**From:** [Connor Armi](#)  
**To:** [Chace Pedersen](#)  
**Cc:** [Guy Moura](#); [Hanson, Sydney \(DAHP\)](#)  
**Subject:** Re: SP-23-00007 Nelson View - Notice of Application  
**Date:** Thursday, November 2, 2023 11:47:51 AM

RE: SP-23-00007 Nelson View

**TO:** All Staff  
**FROM:** Public Works Plan Review Team  
**DATE:** November 16<sup>th</sup>, 2023  
**SUBJECT:** SP-23-00007 Nelson View

Figure 1. LiDAR imagery of the channel scar through the project area, west of Big Creek.

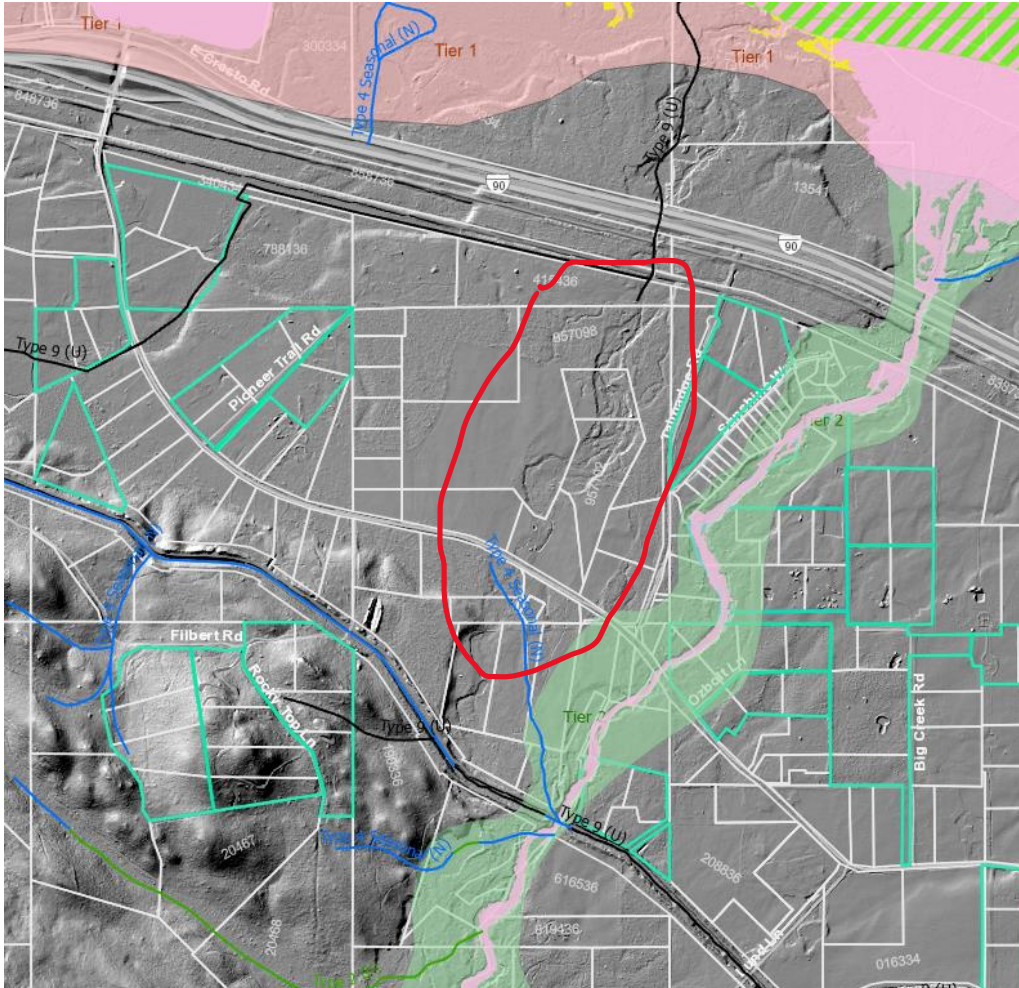
While the project area is not immediately adjacent to Big Creek, the LiDar clearly shows a relic channel through several of the proposed lots (Figure 1), specifically lots 6, 9, and 10. If you follow the scar upgradient, it may be that this scar represents the historic irrigation channel, that was likely an old Big Creek channel in geologic time. Where this channel appears to start is just south of the KRD's canal and within the mapped Channel Migration Zone for Big Creek. This could result in channel avulsions or flood flow conveyance through the relic channel that the proponents/owners should be made aware of, despite not being mapped as a special flood hazard area by FEMA.

- A critical areas report should be submitted for the project because there appear to be potential wetlands present and there are untyped streams present at the northern portion of the property. The critical areas report should also cover the geological hazards associated with the channel migration zone along Big Creek that may result in flow entering the channel scar through the project area. This project area is mapped as a Tier 1 for Critical Aquifer Recharge Area as well. The Critical Areas report should address all 5 critical areas that may be present or near the project area. The untyped stream mapped at the northern extent of the property appears to have conveyance infrastructure through the railroad grade and Interstate 90, connecting it to the Yakima River. This channel may provide fish habitat and warrants further investigation.

KITITITAS COUNTY		WASHINGTON	
DWN BY	DATE	JOB NO.	
D.L.P./G.W.	9/15/23	230162	
CHKD BY	SCALE	SHEET	
D.L.P./D.B.M.	1"=200'	2 OF 2

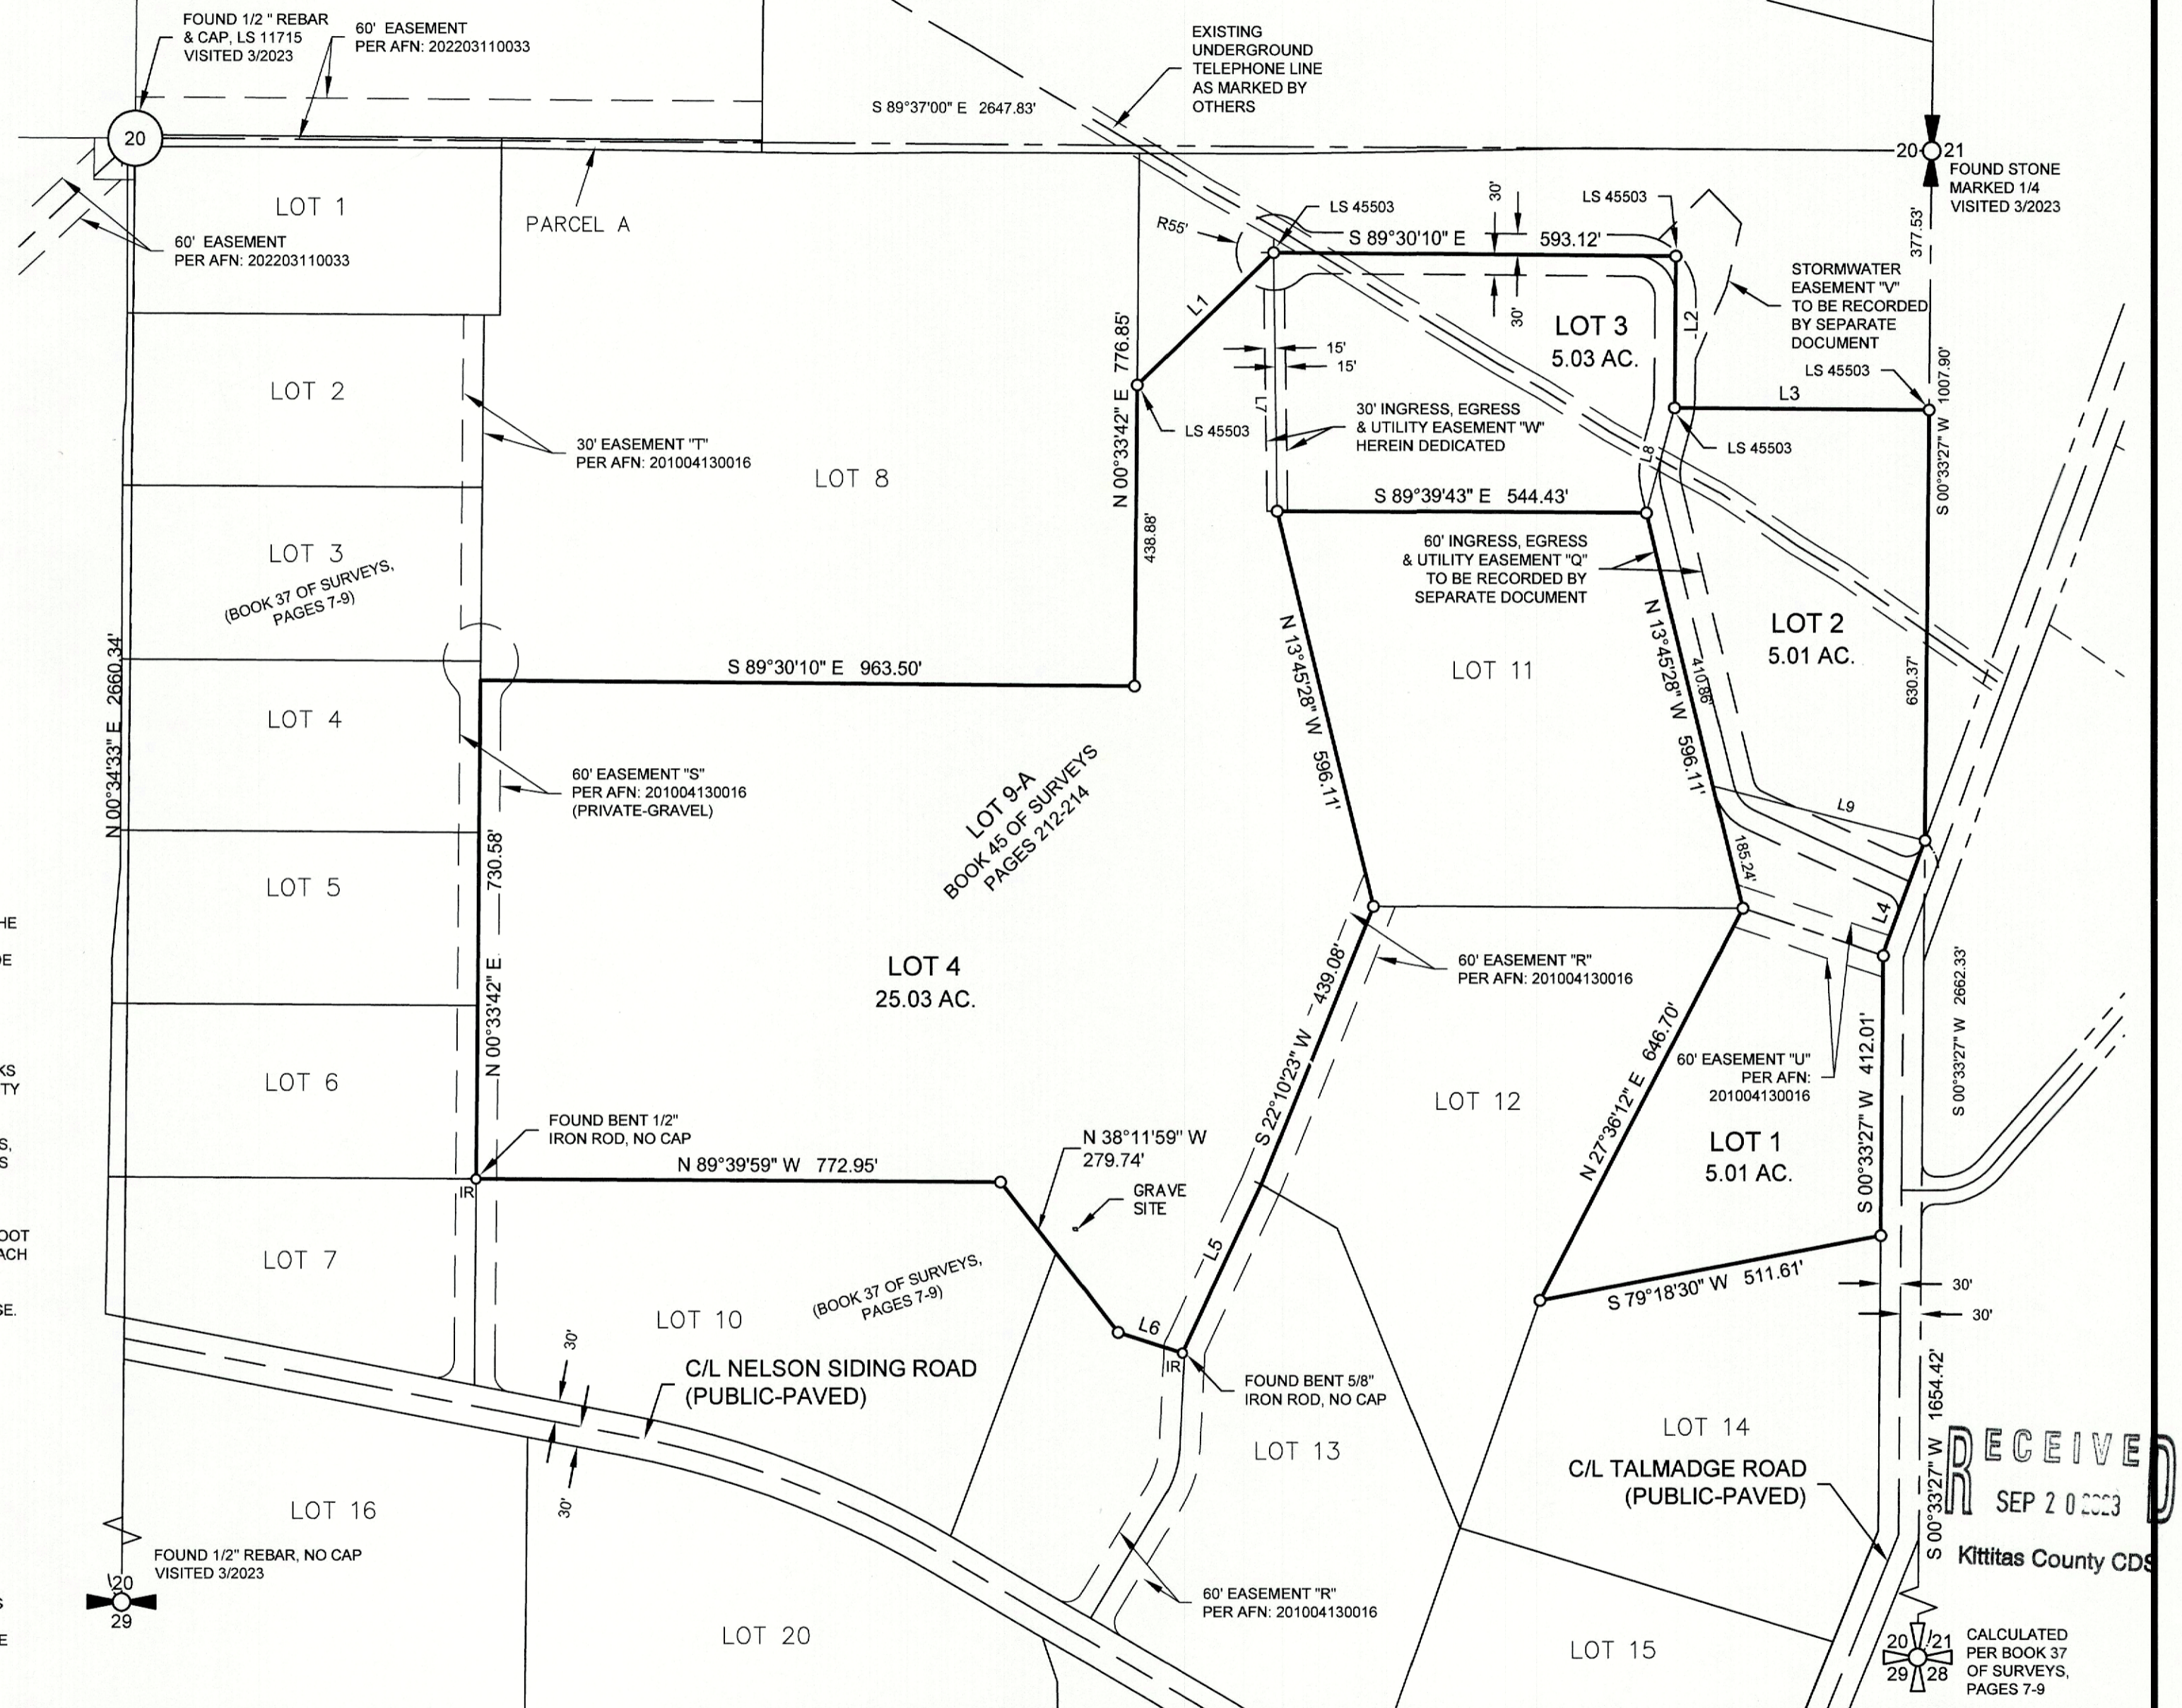
<b>SURVEY</b>	<p>Regarding the Preliminary Plat:</p> <p>1. The Preliminary Plat does not meet the requirements of WAC: 332-130-145 in regards to topographic elements.</p> <p>The following will need to be addressed prior to Final Short Plat approval:</p> <ol style="list-style-type: none"> <li>1. Per Note 5, Sheet 1, access to Lot 1A is via a private easement. No Lot 1A shown on the face of this Short Plat. If this note is to remain, Lot 1A shall be shown as well as Pioneer Trail Road shall be labelled.</li> <li>2. Notes 6, 8 and 9 all reference different basis of bearings statements, and make references to Lots not shown on the face of the Short Plat. Please resolve, and if multiple Basis of Bearing were utilized, please include the rotation and direction (clockwise or counterclockwise), that was used to put it in the final rotation shown on the map.</li> </ol> <p>Of Note (changes not required)</p> <p>As the proposed access easement is not mathematically retraceable, please ensure the separate document includes and mathematically retraceable description, and does not simply reference the Short Plat.</p>
